Memorandum

Re: Mixed Use Development at 321 Commercial Street; Level III Site Plan/Subdivision, J B Brown & Sons Applicant.

Project #: 2012-615 **CBL:** 40-E-3

Meeting Date: November 13, 2012

DATE: 10-22-12
 SCALE: 1"=20'
 DRAWN BY: EJS
C05
 SHEET: 5 OF 13

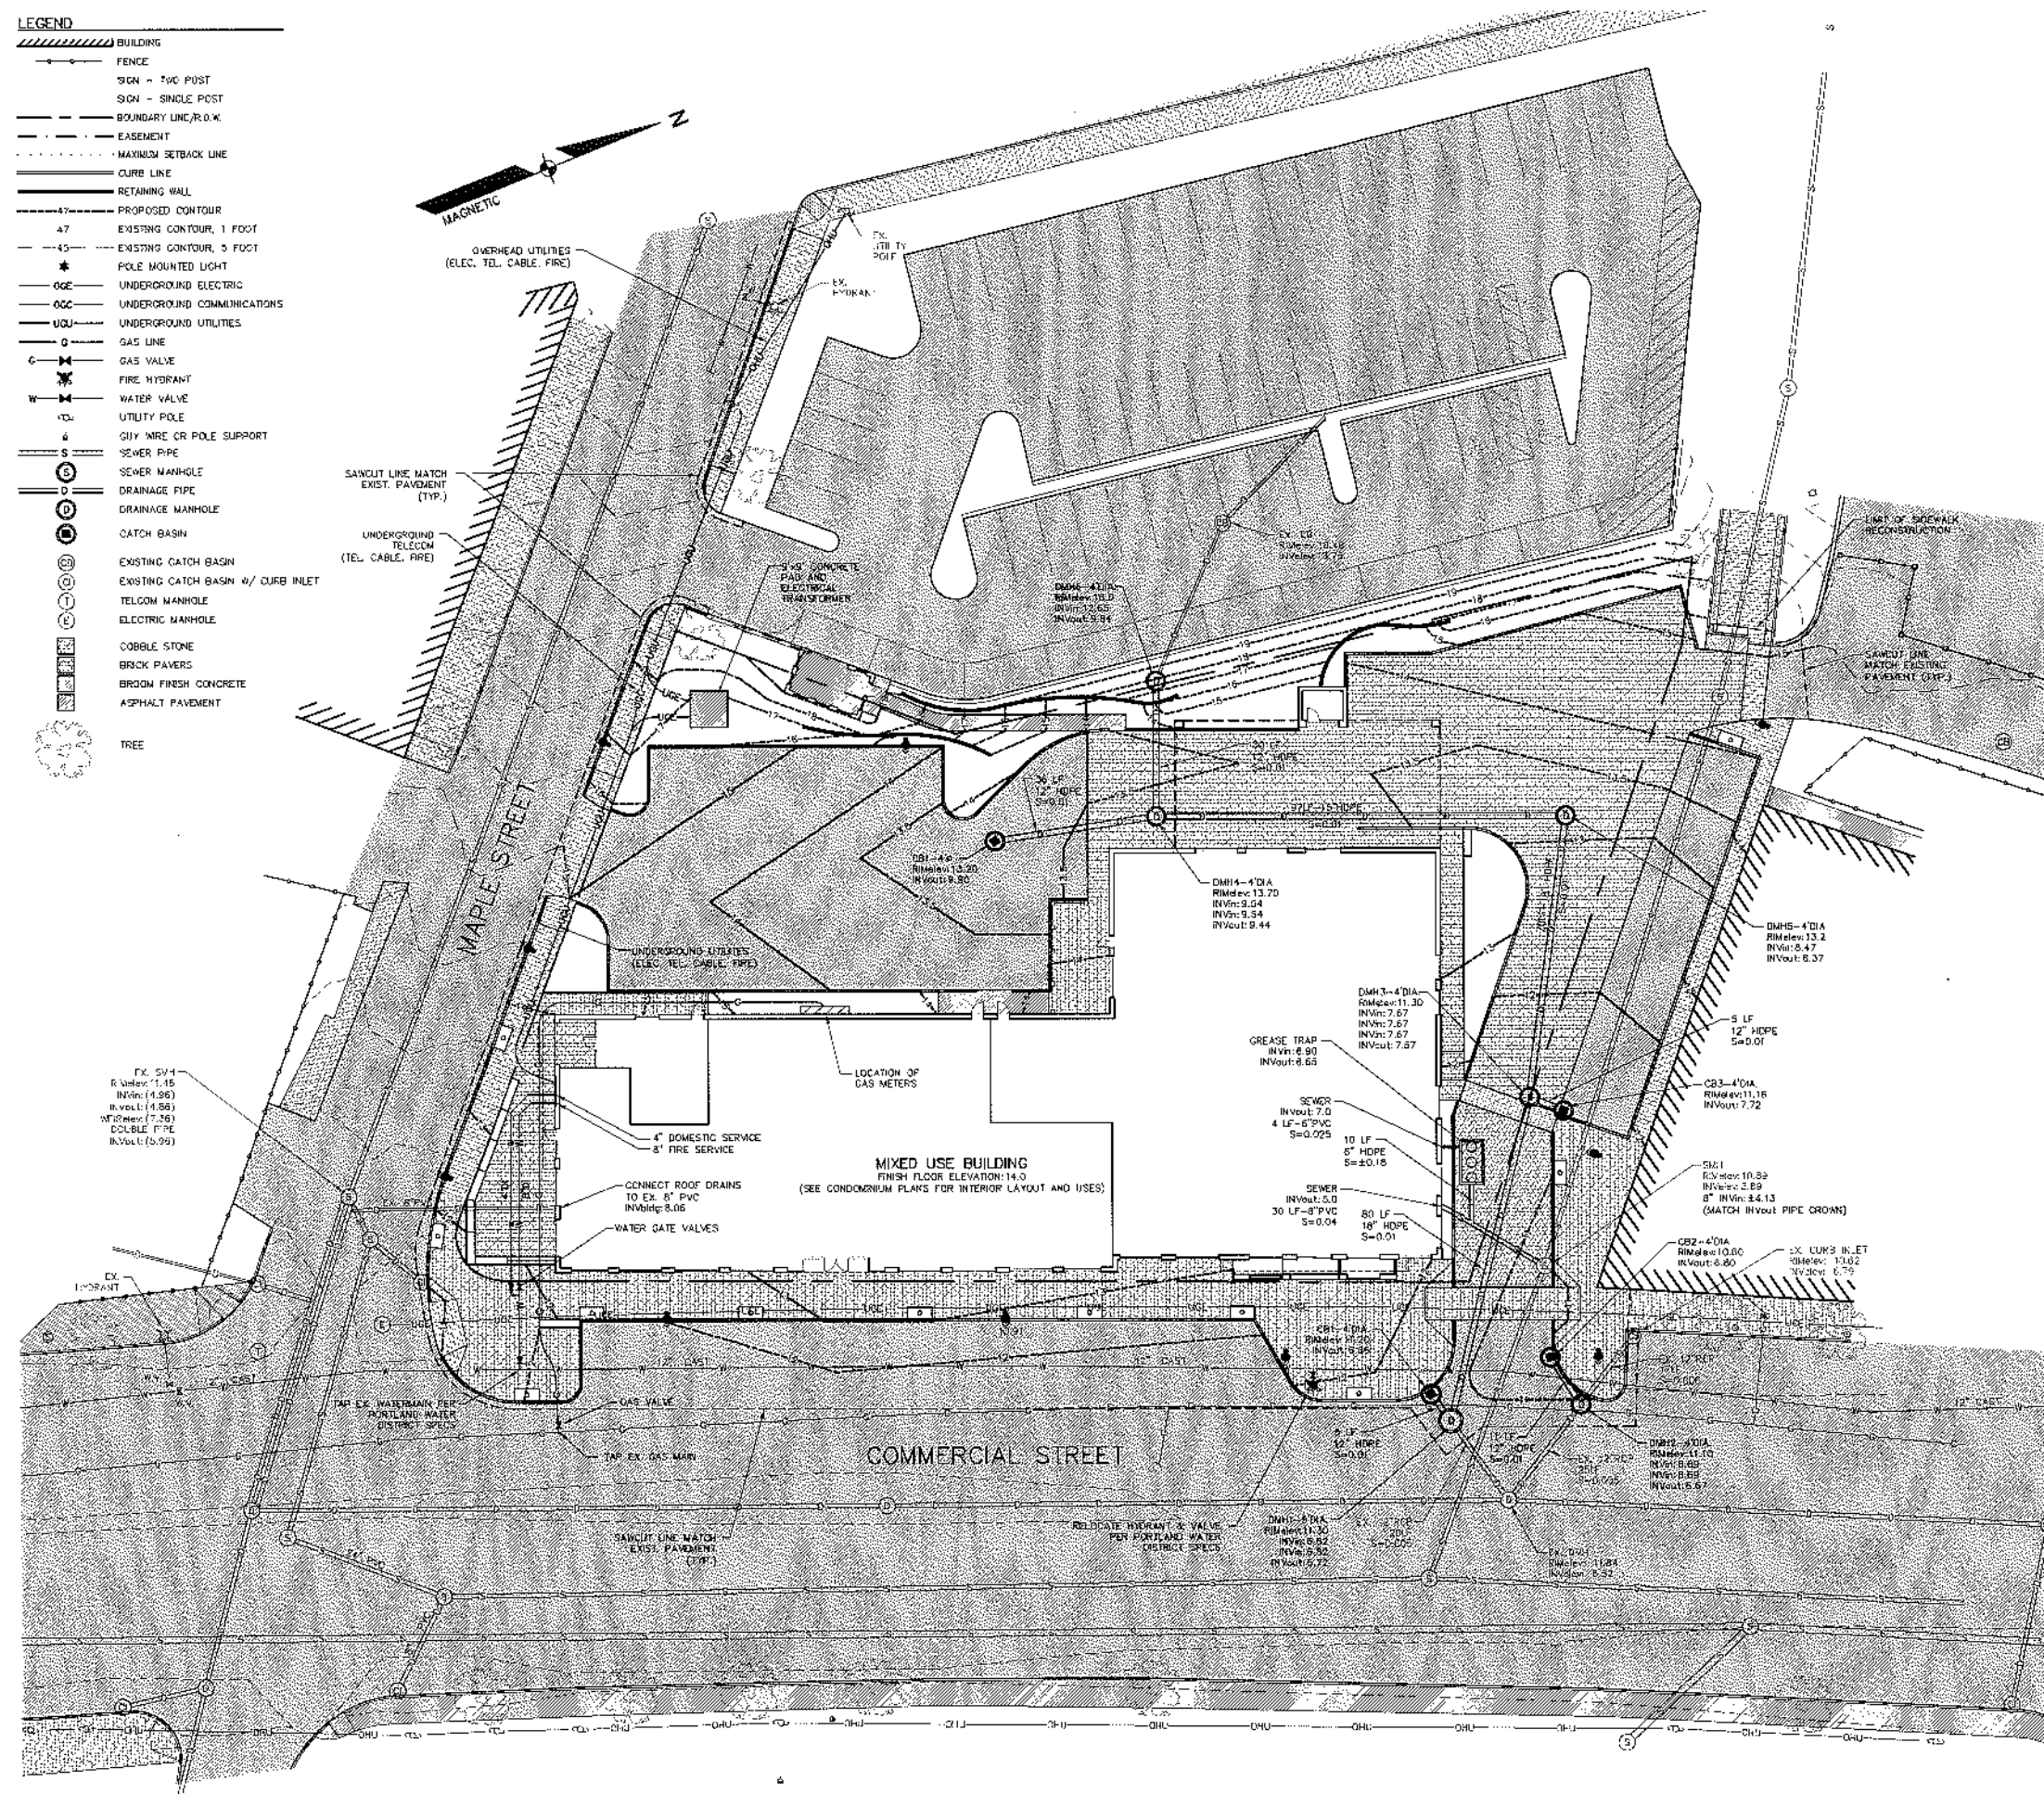
- *The driveway on Maple Street will require a waiver from the City's technical standards for driveway separation. Give the volume and speed of traffic on Maple Street I support a waiver from the City's technical standards.*

- *The painted areas at the driveway entry on Maple Street should be removed.*
- *The applicant has illustrated a proposed crosswalk on Commercial Street at the easterly corner of Maple Street. I need to review this proposal. My general sense is additional features are needed for safe pedestrian crossing. I would also note that the alignment of the crosswalk on the site plan will need to be adjusted to meet the City's perpendicular alignment design preference. The crosswalk paint detail would also need to be "Block" style.*

- *The applicant should provide details on how truck deliveries will be accommodated.*

- I need to review the design details on the diagonal parking on Commercial Street (e.g. dimensions, painted corner areas, etc.).
- For on-street parking changes, a city council approval will be required. The applicant will be responsible for providing materials in support of the Parking Schedule change.

GRADING PLAN

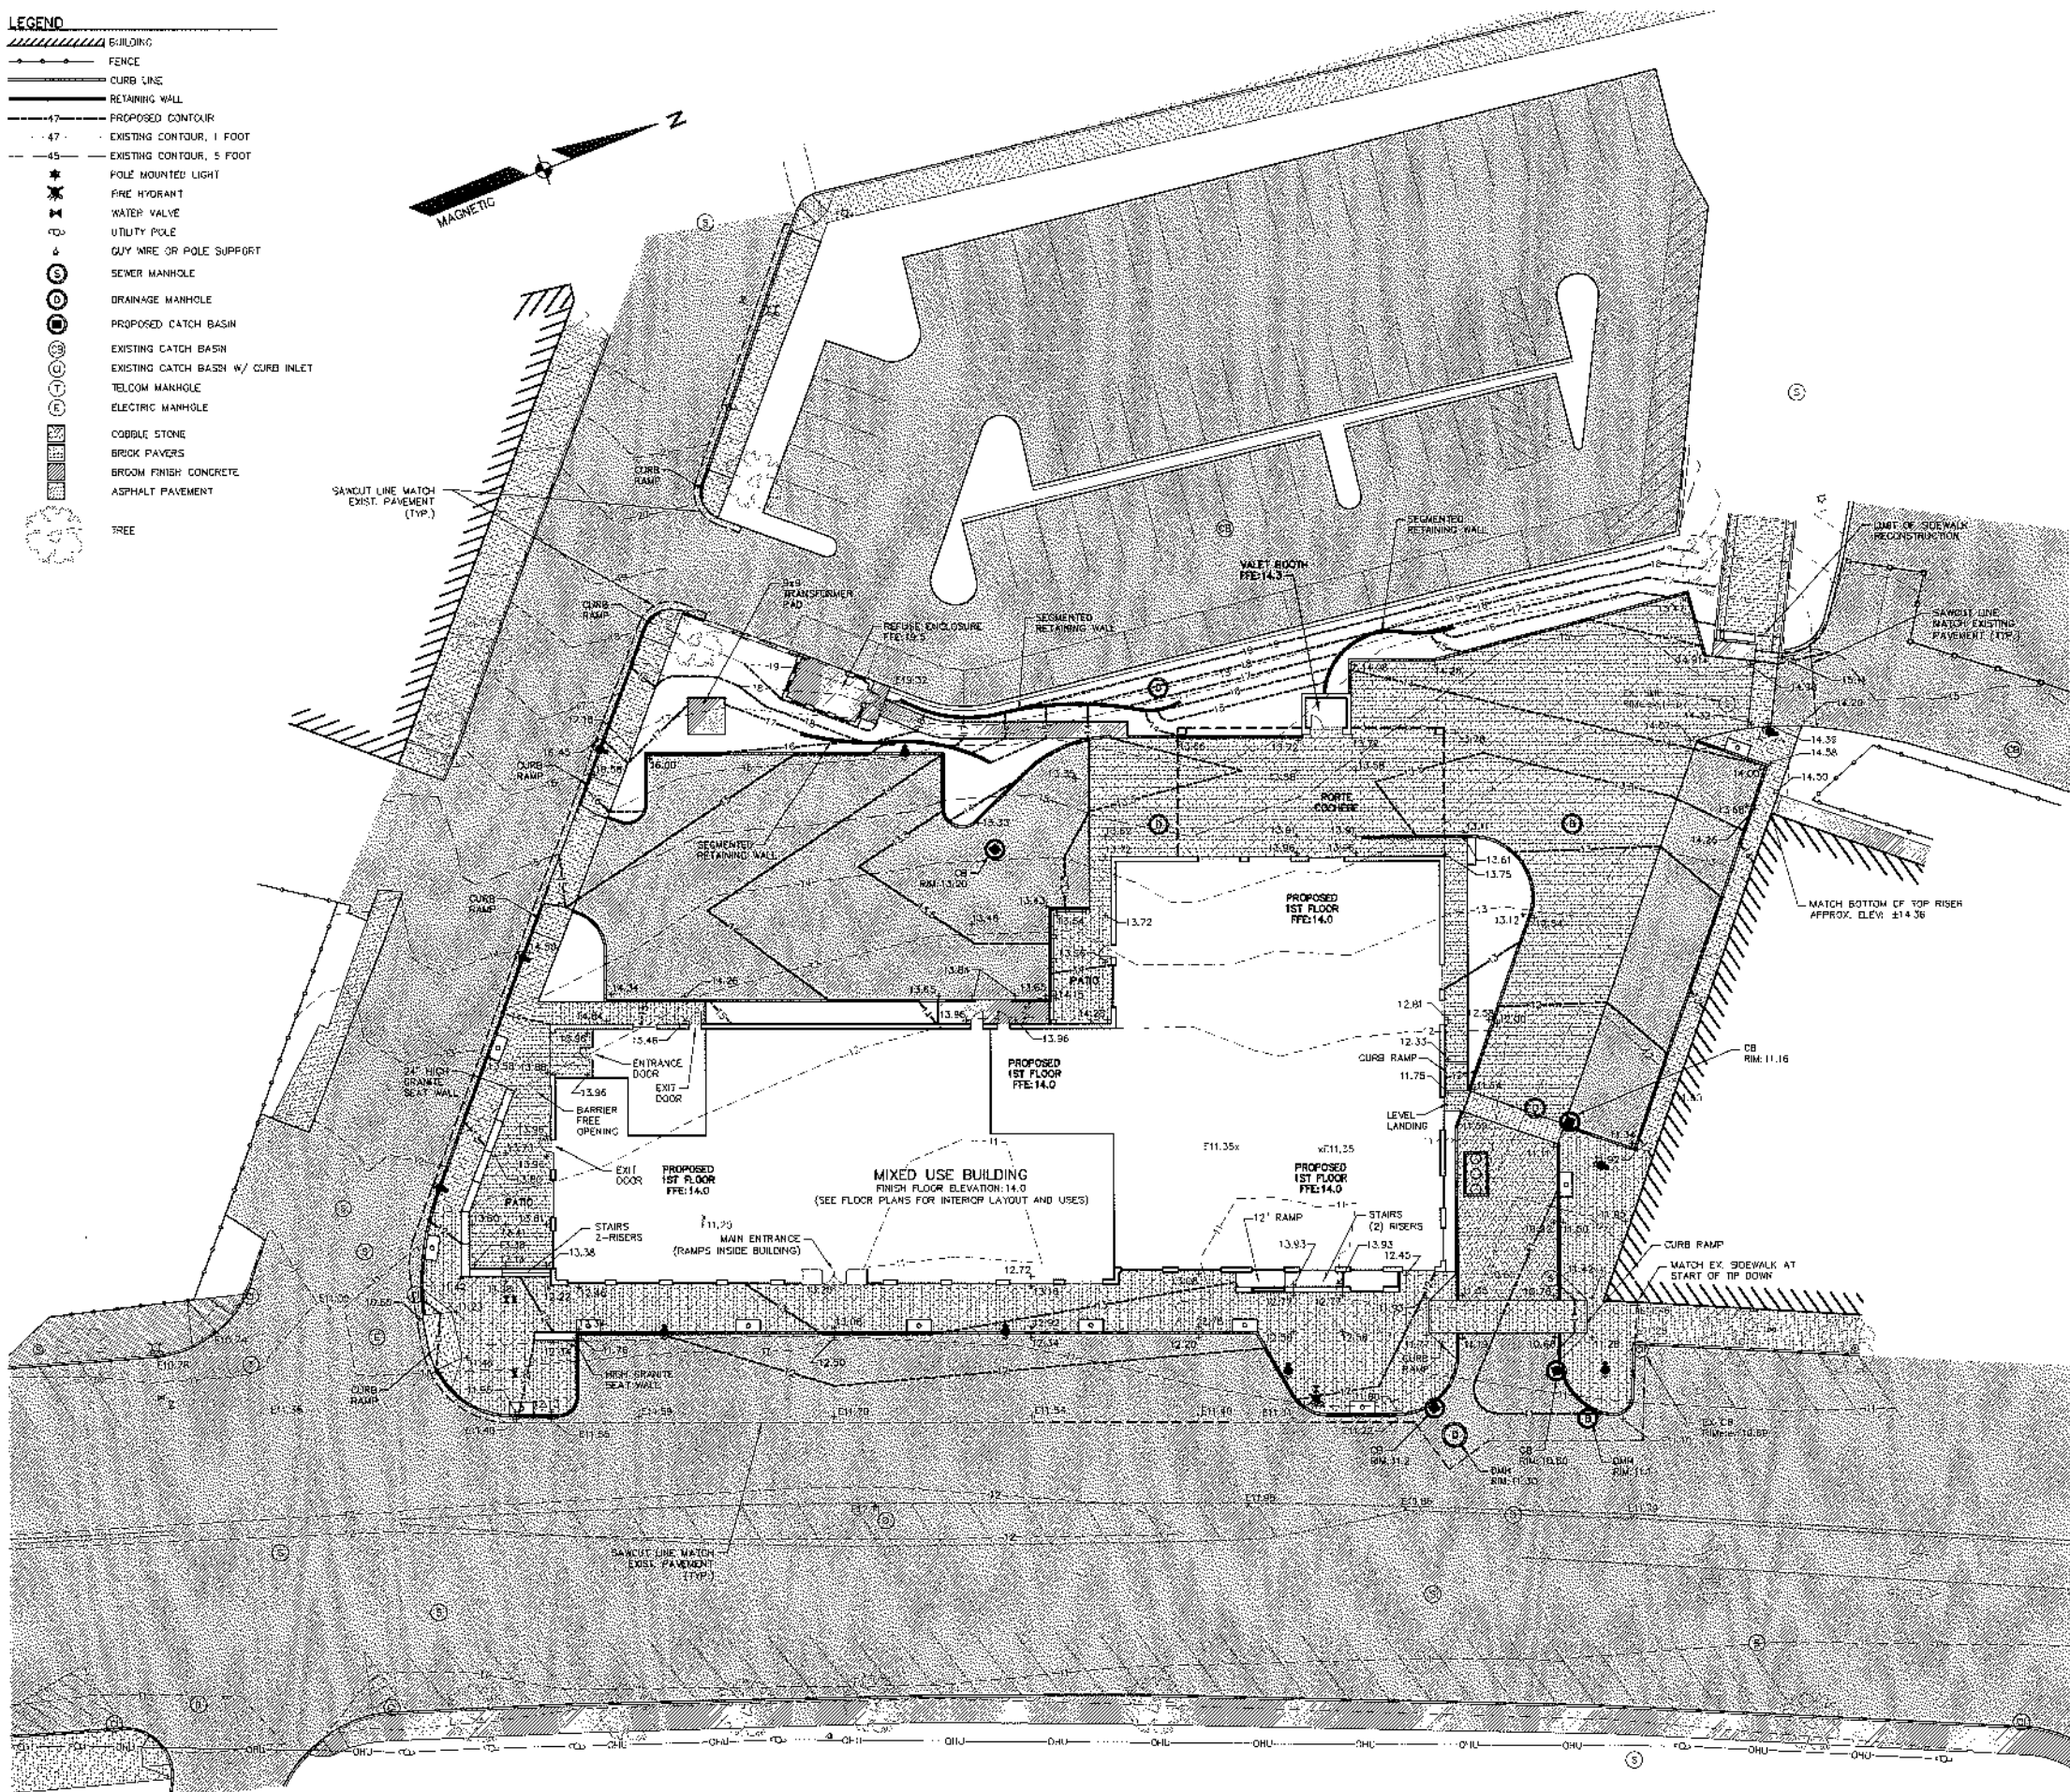
The zoning analysis stated that an average building grade calculations were attached. I could not find that page. Please direct me to where that information is located or provide separately. The elevations indicate that the average grade is 13.5 elevation. Based on that unverified information, the height of the building is given as 64' 10". The maximum building height is 65'.

The applicant did include the height analysis in the original submissions (Attachment C) and an updated zoning comment will be provided for the workshop. The applicant has clarified that there is no residential unit on the first floor, just the entrance lobby with elevators.
